WESTMEAD CATHOLIC COMMUNITY EDUCATION CAMPUS APPENDIX A - RESPONSE TO SUBMISSIONS AND REQUEST FOR ADDITIONAL INFORMATION AND CLARIFICATIONS

OPEN SPACE - GROUND FLOOR,
OVAL AND LEVEL 01
sheet

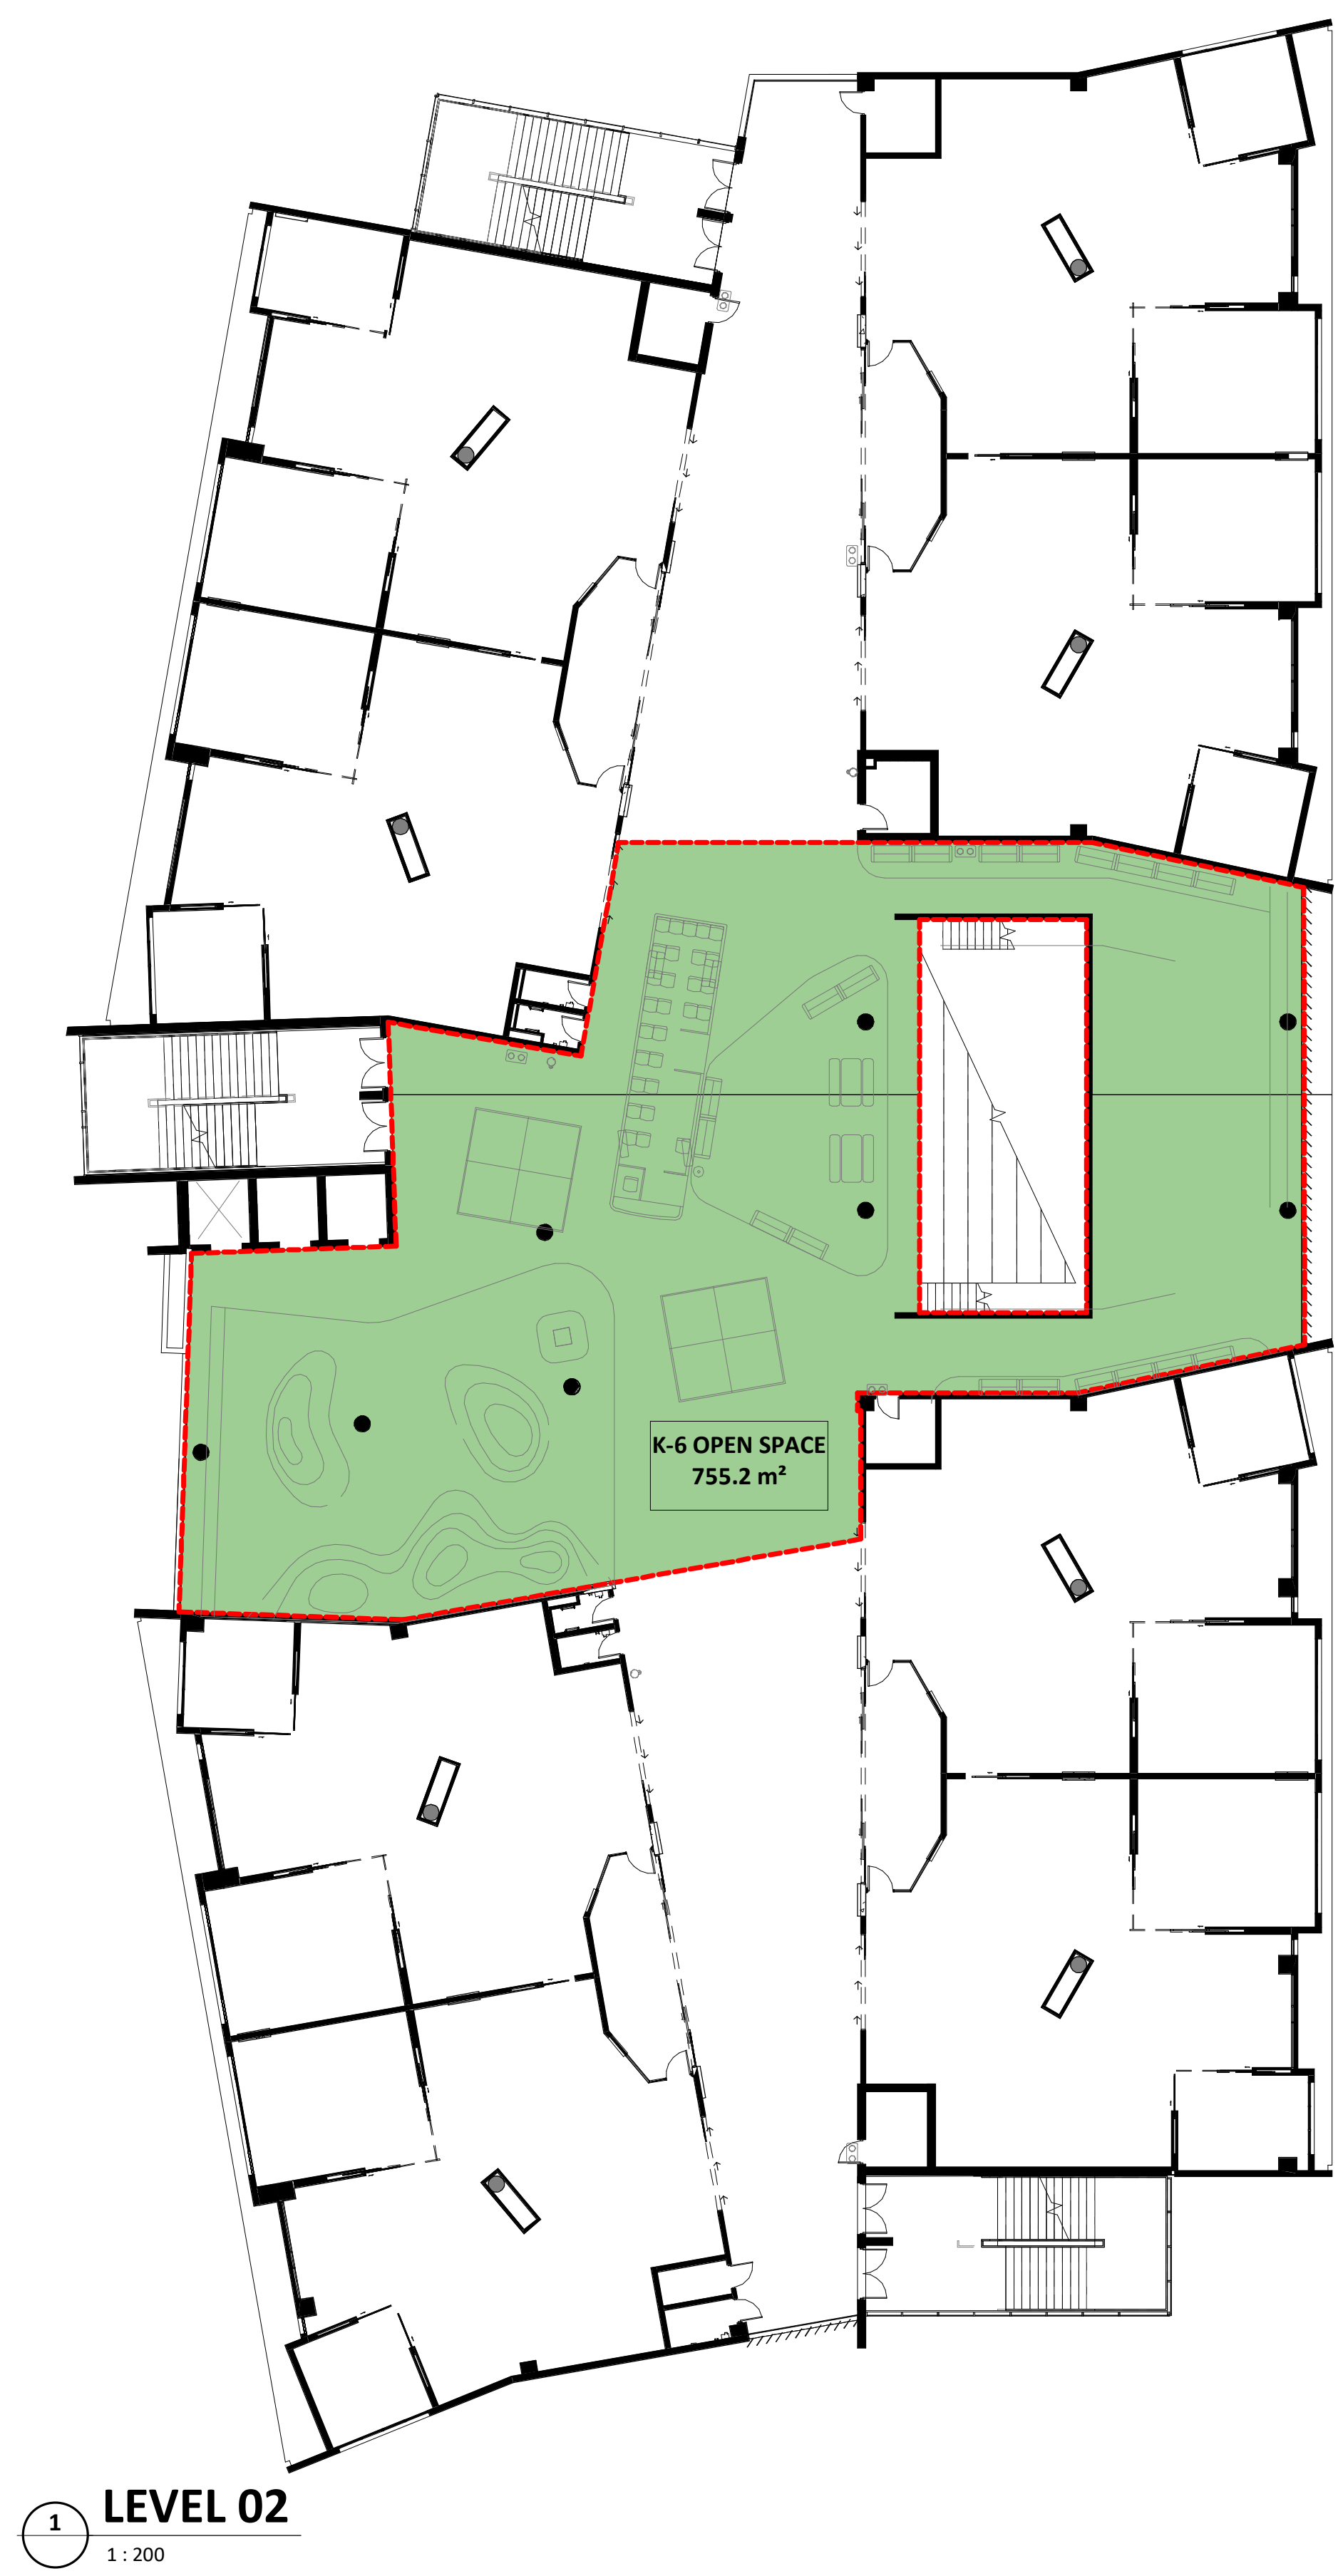
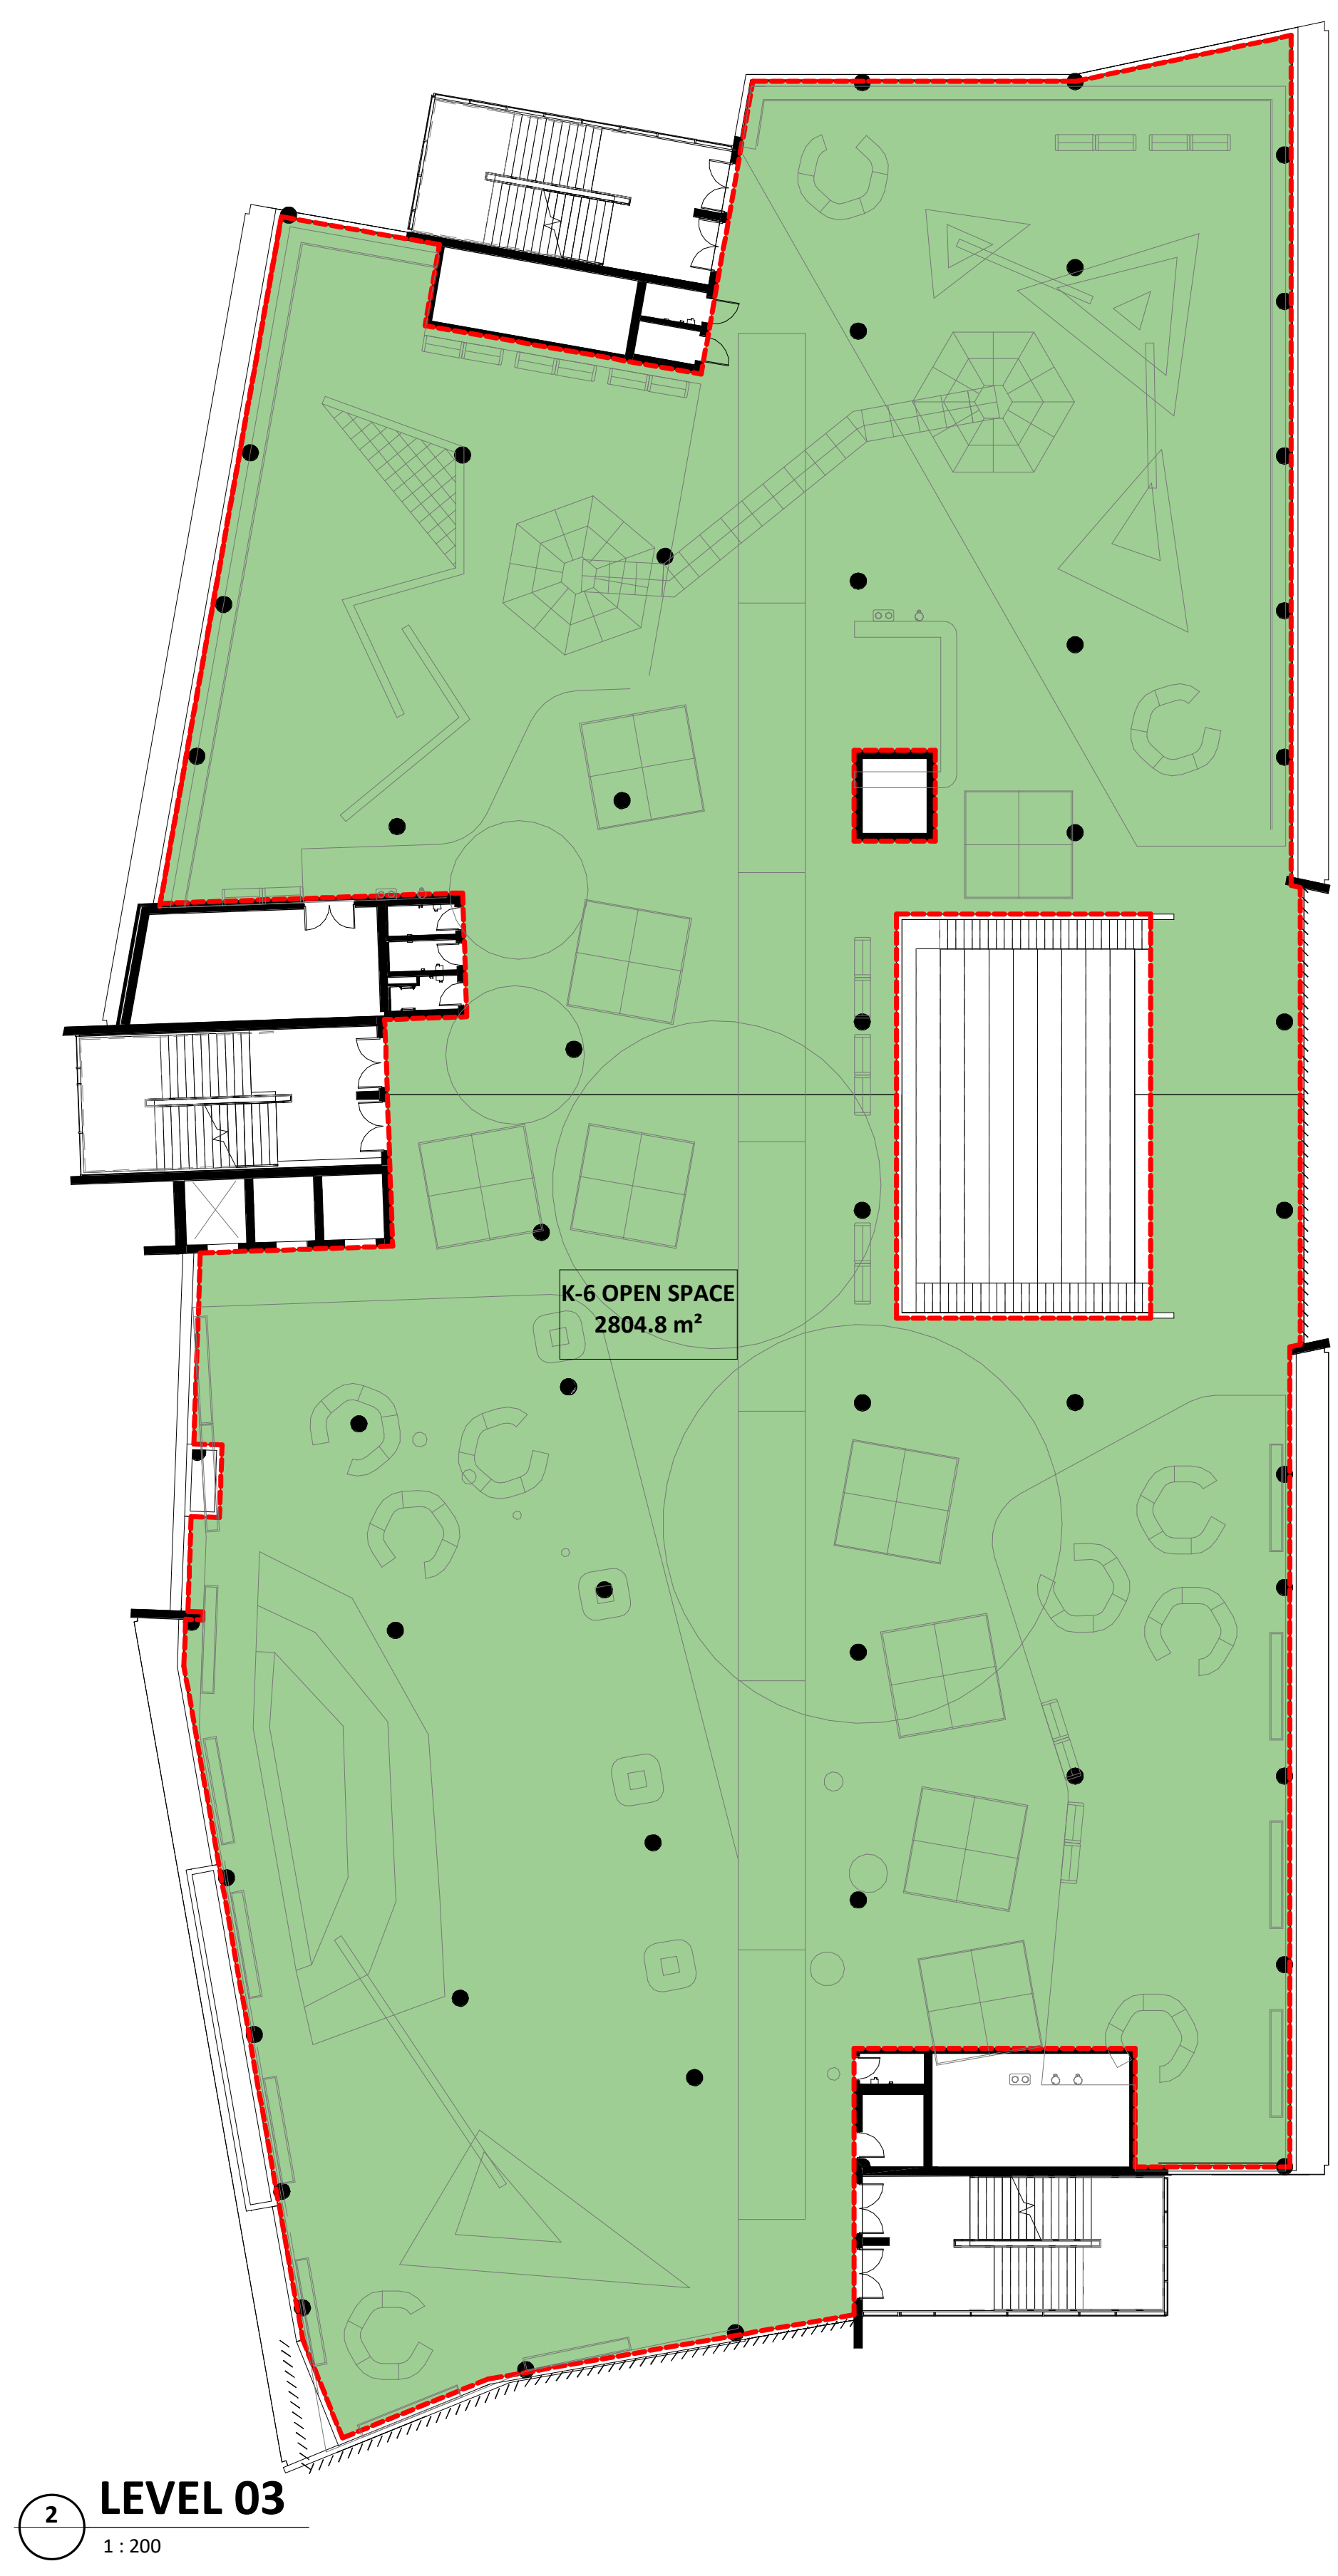
Item No	Name	Type	Issue	Response																		
4			<p>The proposal does not provide the details of the area of open space provided within the building. While there are no minimum requirements for the area of open space per student, Department of Education provides guidance / standards for the minimum area of open spaces required per student within a school. Department of Education's should be used as a guide to demonstrate that suitable open space areas have been provided per student within the site.</p>	<p>Based on these findings, the proposal is considered suitable from a daylight and solar access perspective.</p> <p>A detailed response to the Department's open space comments is provided in the covering Response to Submissions Report.</p> <p>The revised Architectural Drawings (Appendix B) quantify the open space within the building. The diagrams show that there will be over 7,800m² of open space across Levels 1 – 5 (i.e. all ground level play space, including the ground level undercroft, is in addition to this). This equates to 4.6m² per student, within the building. The plans outline that the open space has been specifically located so that the relevant open space for each age group is within one floor of the learning areas. This ensures that each year group will have direct access during mid-morning and lunch breaks, with no wasted time travelling to access these open spaces.</p> <p>On ground level, there is an additional 6,070m² of open space. This includes the undercroft and outdoor area adjacent to the new Primary School Building, but excludes the ovals. This additional area equates to 3.6m² of additional open space per student, taking the total open space provision to 8.2m² per student. A summary of these figures is provided below.</p>

<table><tr> <th colspan="2">OPEN SPACE CALCULATIONS</th> </tr><tr> <td>Ground Floor</td> <td>6070.8 m²</td> </tr><tr> <td>Level 01</td> <td>742.6 m²</td> </tr><tr> <td>Level 02</td> <td>755.2 m²</td> </tr><tr> <td>Level 03</td> <td>2804.8 m²</td> </tr><tr> <td>Level 04</td> <td>786.7 m²</td> </tr><tr> <td>Level 05</td> <td>2777.3 m²</td> </tr><tr> <td></td> <td>13937.4 m²</td> </tr></table>

<p>Open Space Ratio 8.23 m²/student</p> <p>For clarity, the primary children will access the ovals for delivery of the PDHPE curriculum but they are not included in the play space calculation. More broadly, at the completion of the Master Plan, there will be more play space area per student than recommended by the EFSG. Preliminary figures indicate that the total area per student will be approximately 20% greater than the EFSG at the completion of Project 1, Stage 2 (refer to details of Master Plan below).</p>	OPEN SPACE CALCULATIONS		Ground Floor	6070.8 m ²	Level 01	742.6 m ²	Level 02	755.2 m ²	Level 03	2804.8 m ²	Level 04	786.7 m ²	Level 05	2777.3 m ²	Not Placed	Not Placed		13937.4 m ²
OPEN SPACE CALCULATIONS																						
Ground Floor	6070.8 m ²																					
Level 01	742.6 m ²																					
Level 02	755.2 m ²																					
Level 03	2804.8 m ²																					
Level 04	786.7 m ²																					
Level 05	2777.3 m ²																					
Not Placed	Not Placed																					
	13937.4 m ²																					
5			<p>The open space diagrams indicate that circulation areas in between classrooms have been added as open spaces. The circulation areas should be deleted from the calculation of open space areas.</p>	<p>All spaces are used as multi-purpose spaces – circulation spaces will be used for access, play and learning. It is also noted that peak play times and circulation times are different, and so it is appropriate for circulation areas to be considered as part of the open space calculation.</p>
